Sign Plan_V1.pdf Markup Summary

**11769 E HWY 24,
PEYTON CO 80831
SITE# CK NTI 2741173 PEYTON CO**

05/18/2022_VB/KS
CK_NT PEYTON_CO_B

STATION ID: CK NTI PEYTON CO

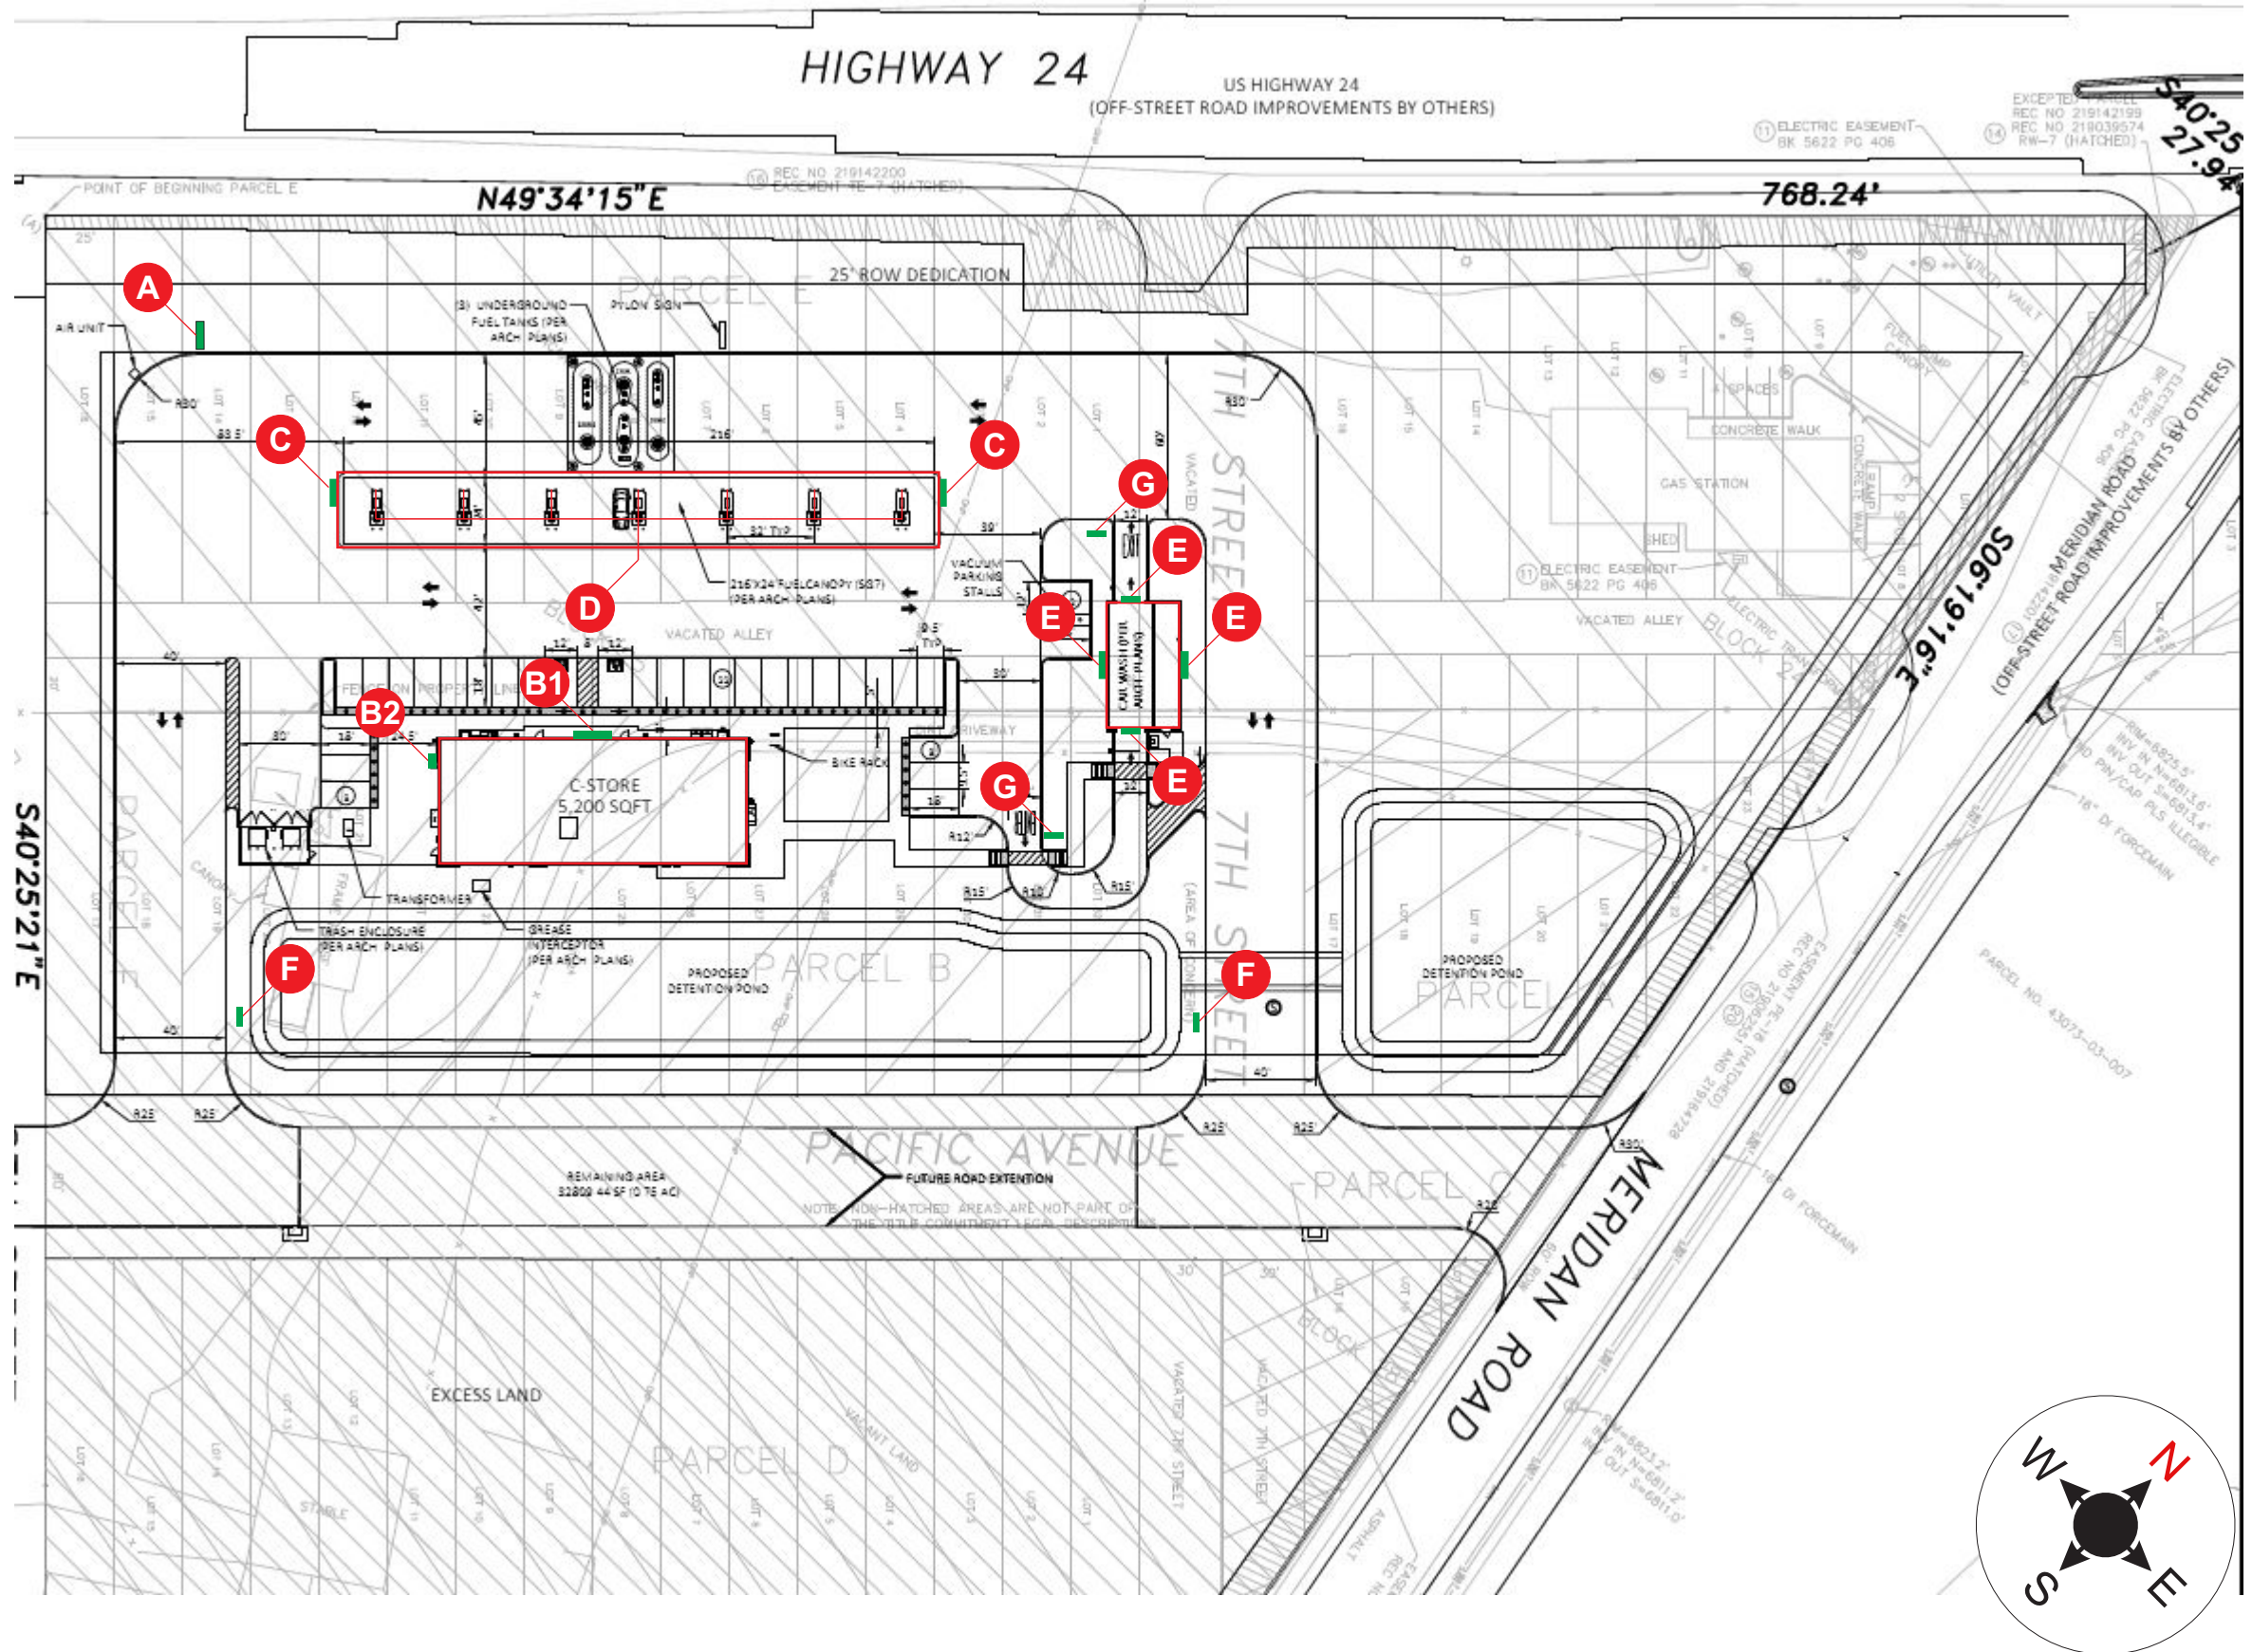
Include summary of square footage of
total allowed signage and existing and
proposed signage for the property

Include comment on sign plan
as follows: Illuminated sign
meets all requirements of EPC
LDC 6.2.10
